Re: Engineering Services
2665 Ash Ave.
Dunn, NC

Tyndall Project No.: 1701-020196

Jul
HARNETT COUNTY CENTRAL PERMITTING
APPLICATION # 1750040951
JOB NAME Rayford McCloud
DATE PLANS RECEIVED 6.3.17
SITE PLANS APPROVED Approved w/exception
APPROVED BY h3 *WJ*

**FIRST FLOOR PLAN**  
 1/8" = 1'-0"      CEILING HT. = 7'-4"

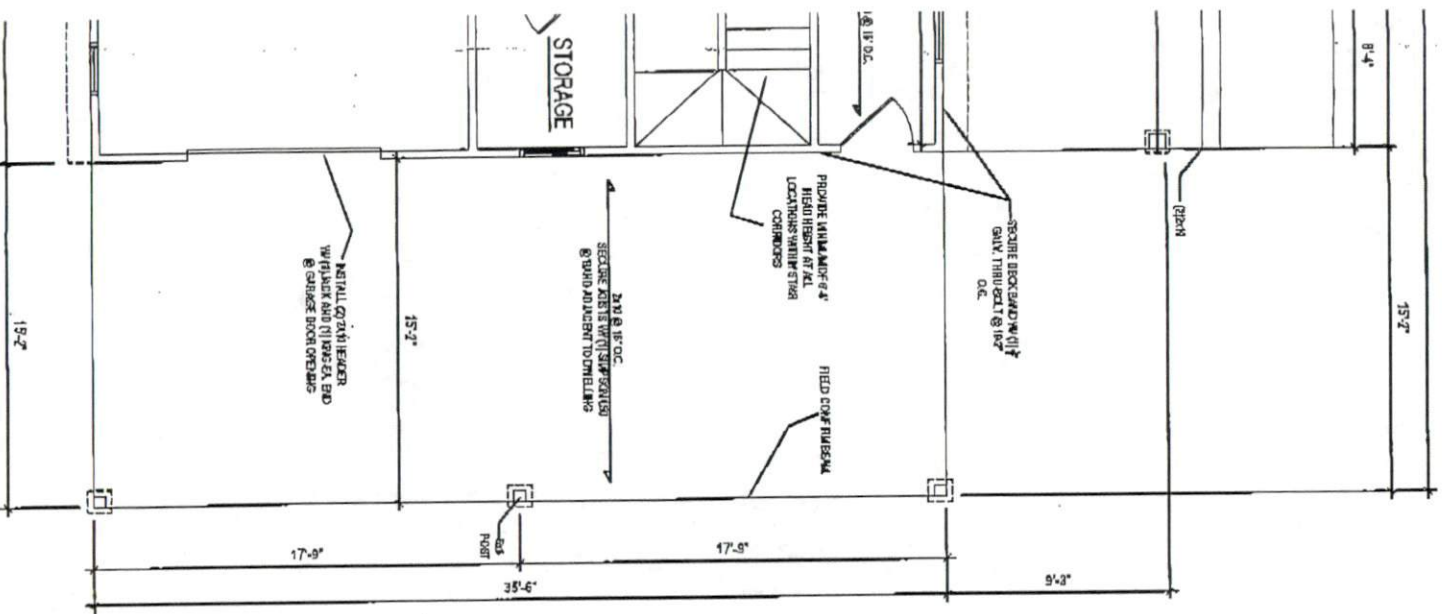
- 1) Floor joists associated with the ground floor were noted as being approximately 8" above the existing crawlspace grade. The existing floor joists were noted as being untreated 2x8 SYP joists placed at 16" O.C.
- 2) Untreated wooden girder members placed in direct contact with masonry associated with the girder support.
- 3) No means of foundation ventilation provided for crawlspace.
- 4) Minimum head height requirements (6'-8") not met at steps leading from 1st floor To 2nd floor.
- 5) Minimum head height requirements not met at 2nd landing encountered during ascension to 2nd floor.
- 6) Header not installed at single car garage door opening.
- 7) 1st floor wall studs 2x4 @ 16" O.C. in-lieu of code 2x6 for 3-story residential structure.

- 1) The joists' proximity to the finished grade does not meet the intent of the NC Residential Building code. TE&D recommends that this condition be addressed with the implementation of one (1) of the following options:

### SECOND FLOOR PLAN

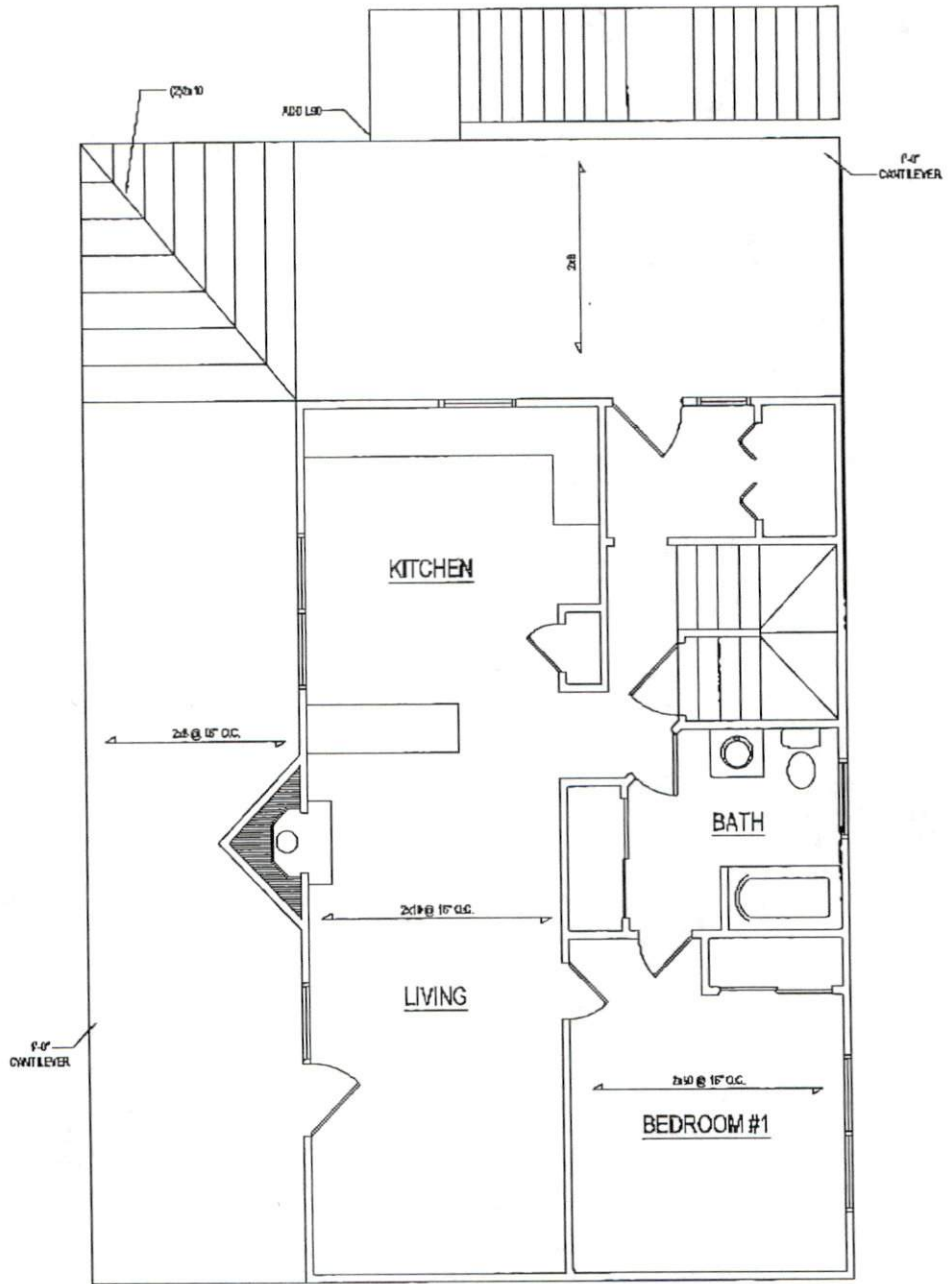
- 8) 4ft. Cantilever (2x10 floor joists) @ 3rd floor balcony.
- 9) Can't confirm roof support beam at covered porch roof located on right side of dwelling.

- 4) This condition occurs at multiple points within the stair corridors. TE&D recommends rebuilding the staircases as necessary to provide minimum head height clearances (6'-8"). Note: Installing a spiral staircase may be an option that could be considered for this item.
